WEST SUSSEX COUNTY COUNCIL CONSULTATION

TO:	Arun District Council FAO: Katie Sharp
FROM:	WSCC - Highways Authority
DATE:	26 September 2022
LOCATION:	Land off Arundel Road Angmering BN16 4ET
SUBJECT:	A/48/22/RES Approval of reserved matters following A/122/19/OUT and varied by A/207/21/PL pertaining to the layout, scale, appearance and landscaping for 160 No dwellings. This application is a Departure from the Development Plan and is in CIL Zone 3 and is CIL Liable as new dwellings.
DATE OF SITE VISIT:	n/a
RECOMMENDATION:	No Objection
S106 CONTRIBUTION TOTAL:	n/a

Refuse Vehicle Swept Path Analysis
Plan View of Refuse Vehicle and Estate Car on Bends

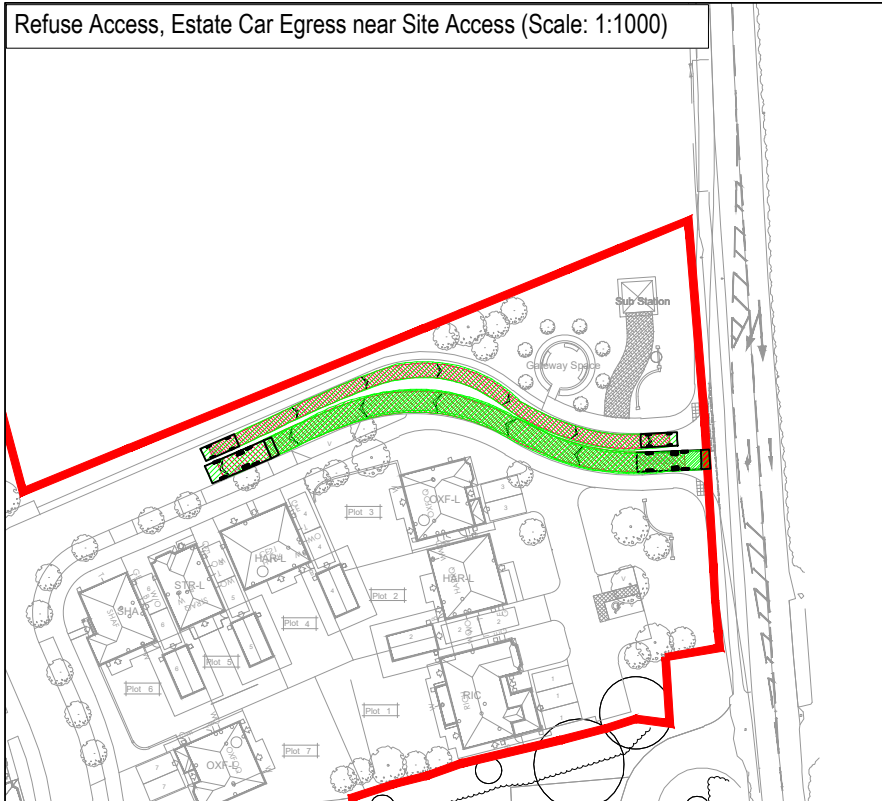
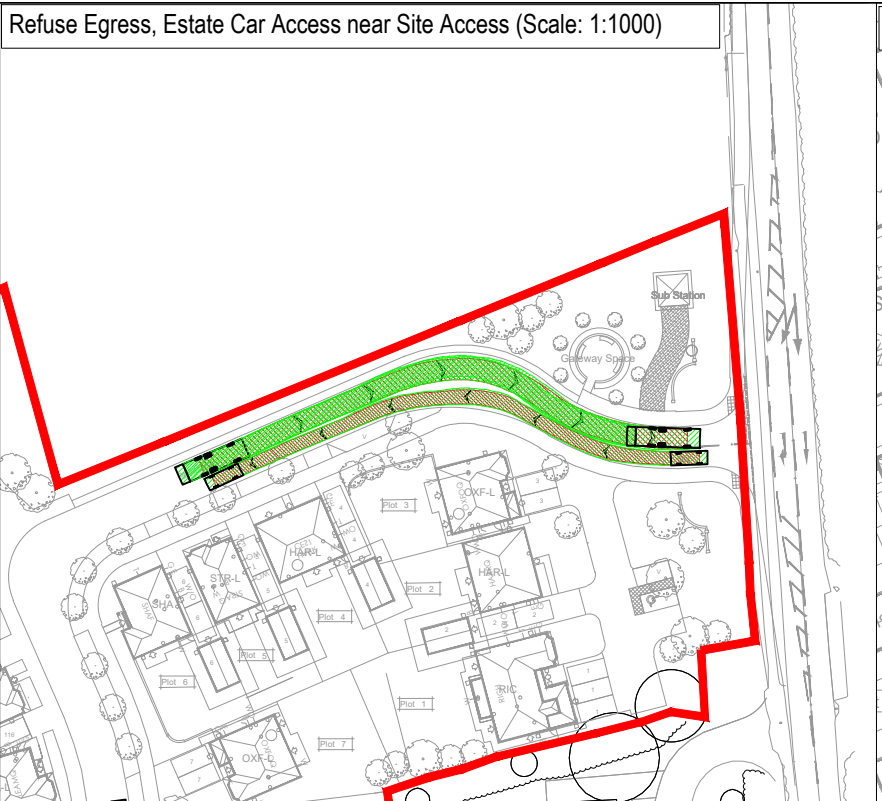
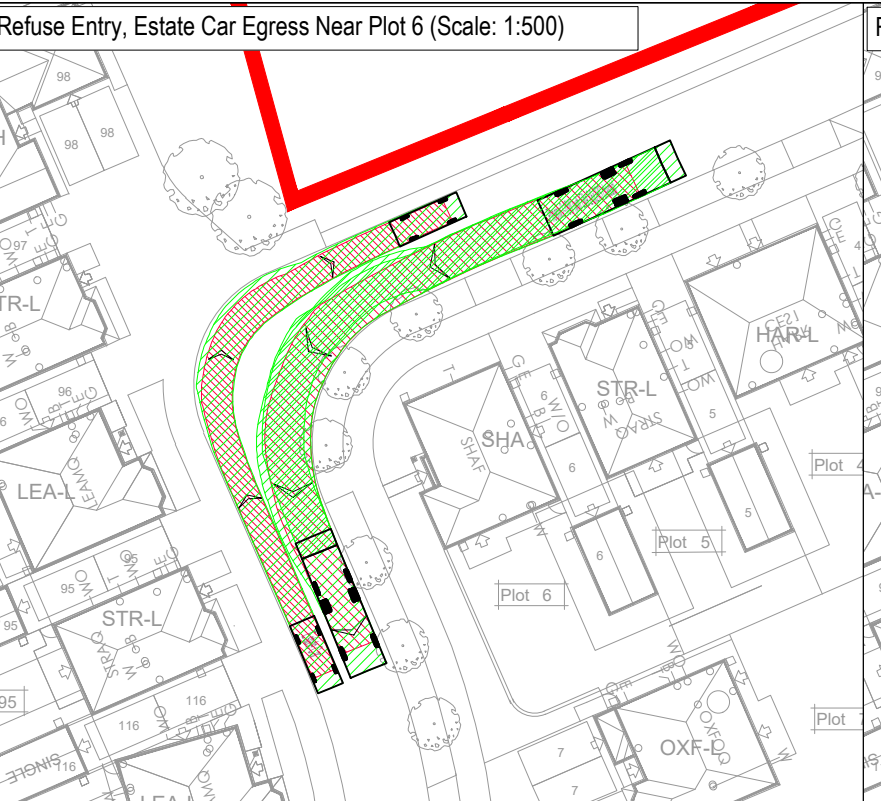
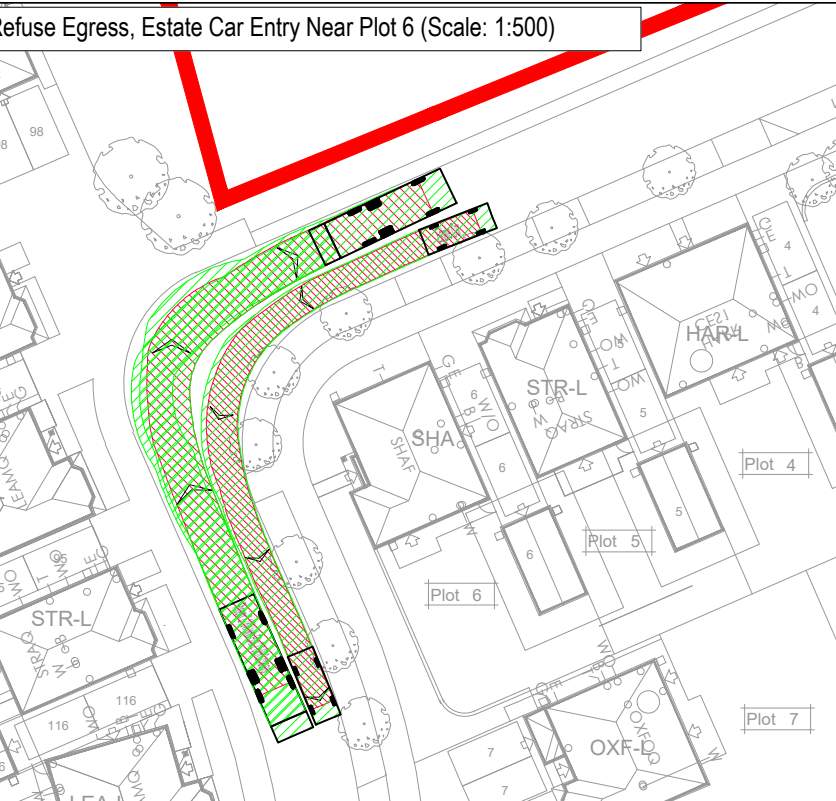
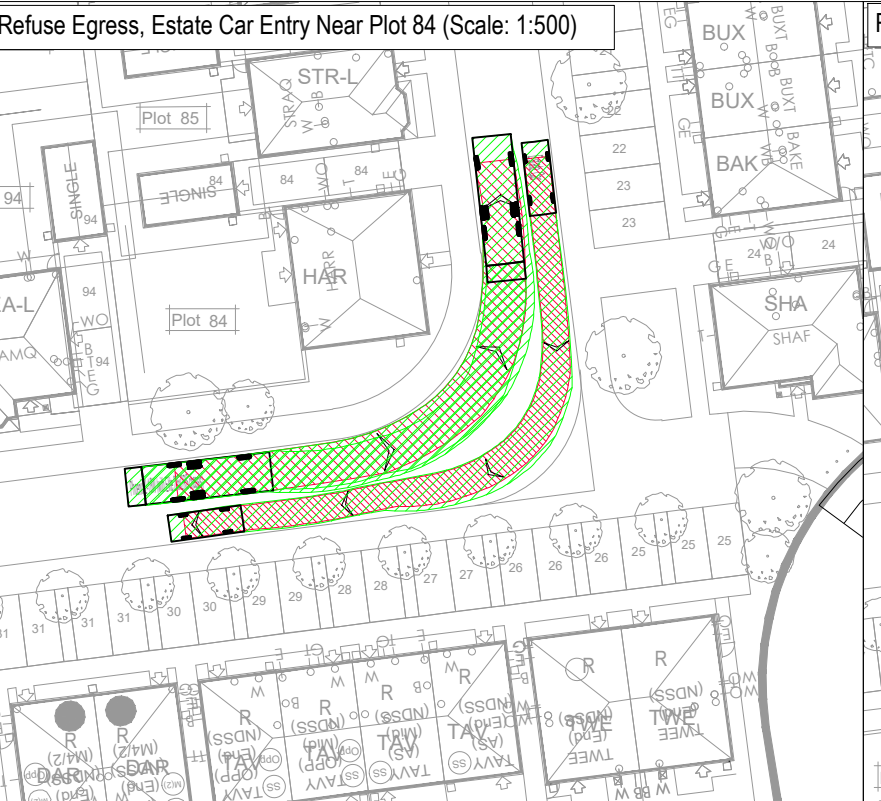
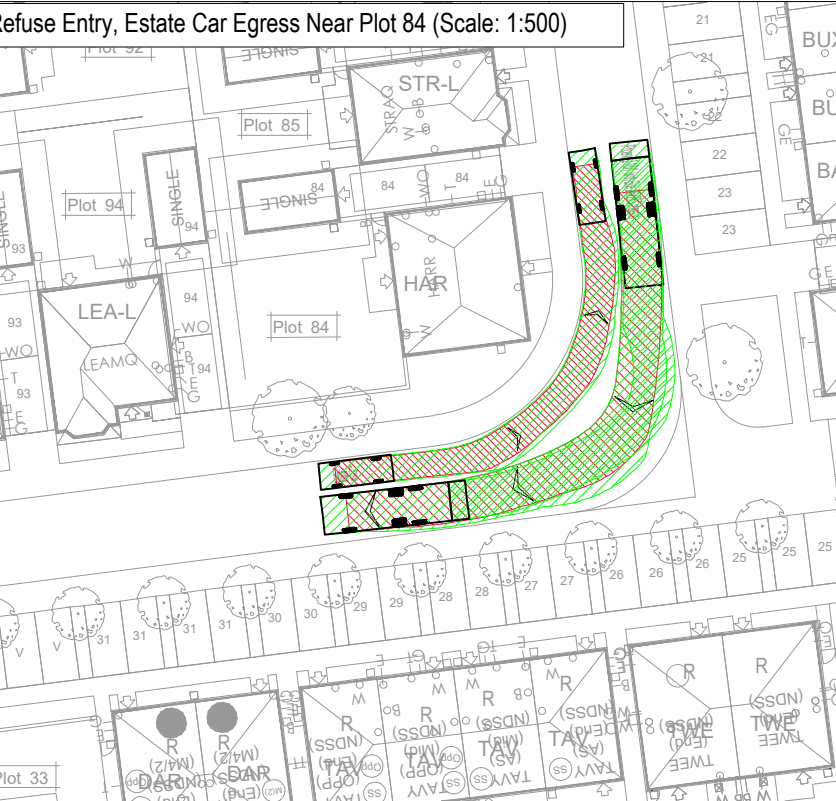
Where refuse vehicle tracking previously extended onto areas that appeared to be residential curtilages these have been amended and the internal highway network (turning heads) extended to ensure that refuse vehicle remains on carriageway.
